Application no: **3/2021/0670**

Address: **Loft Shay Farm Clitheroe Road Ribchester PR3 2YQ**

Proposal: **Conversion of existing agricultural storage building to form one new dwelling, Previous approval 3/2016/0955.**

The Local Highway Authority have viewed the plans and highway related documents and have the following comments to make:

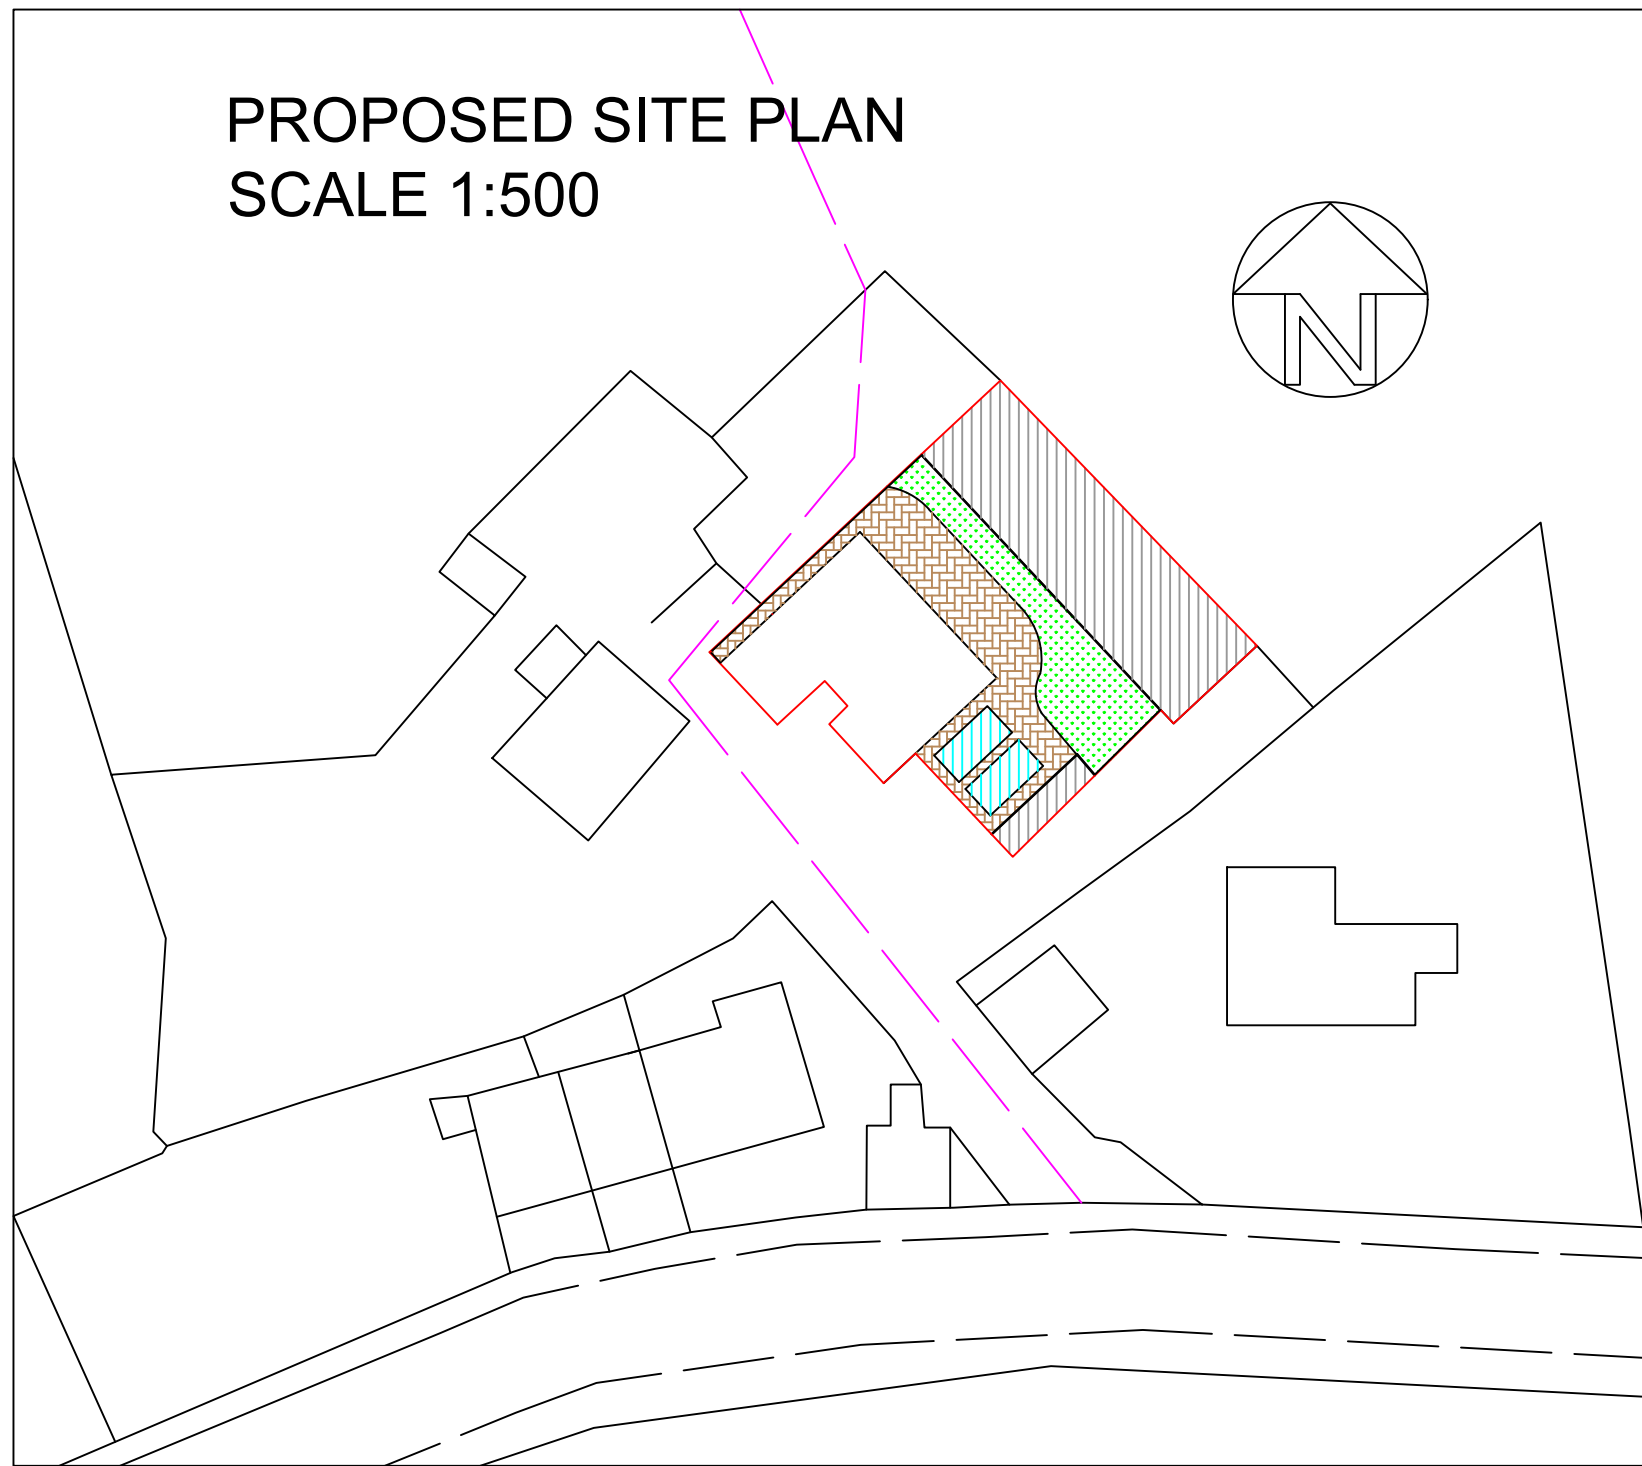
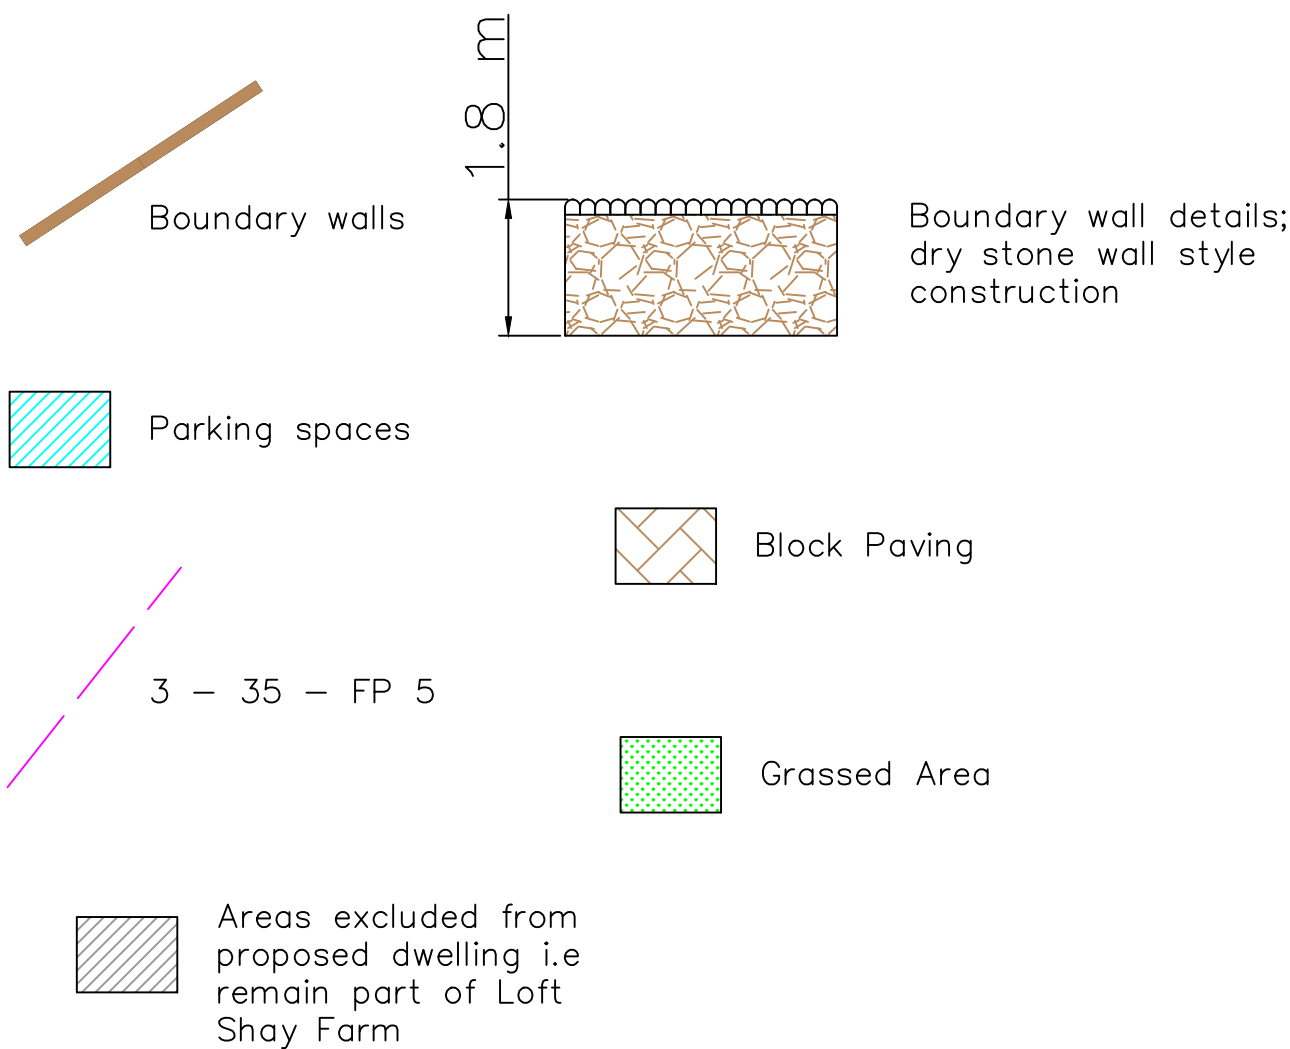
The LHA have reviewed ML drawing number LF/GS/0731 titled "Proposed Plans" and are satisfied that the access arrangements comply with the LHAs guidance. It is also worth noting that the site access was approved under application reference 3/2016/0955 to serve the proposed dwelling at the site. Therefore, the LHA have no objection to the use of the site access.

The LHA have reviewed ML drawing number LF/GS/0731 titled "Proposed Plans" and understands that the site will provide 2 car parking spaces for the 4-bed dwelling.

While this does not comply with the Joint Lancashire Structure Plan which requires a 4-bed dwelling to provide 3 car parking spaces, the LHA will accept the shortfall due to the site being a significant distance away from the public highway. Therefore, occupants of the site will not park on the public highway and instead will park at the site, where there is adequate space to provide the maximum parking standards as defined in the LHAs guidance. As a result the LHA have no further comments to make.

3. No part of the development hereby permitted shall be occupied until such time as the access arrangements shown on ML drawing number LF/GS/0731 have been implemented in full.

4. The development hereby permitted shall not be occupied until such time as the parking and turning facilities have been implemented in accordance with ML drawing number LF/GS/0731. Thereafter the onsite parking provision shall be so maintained in perpetuity.
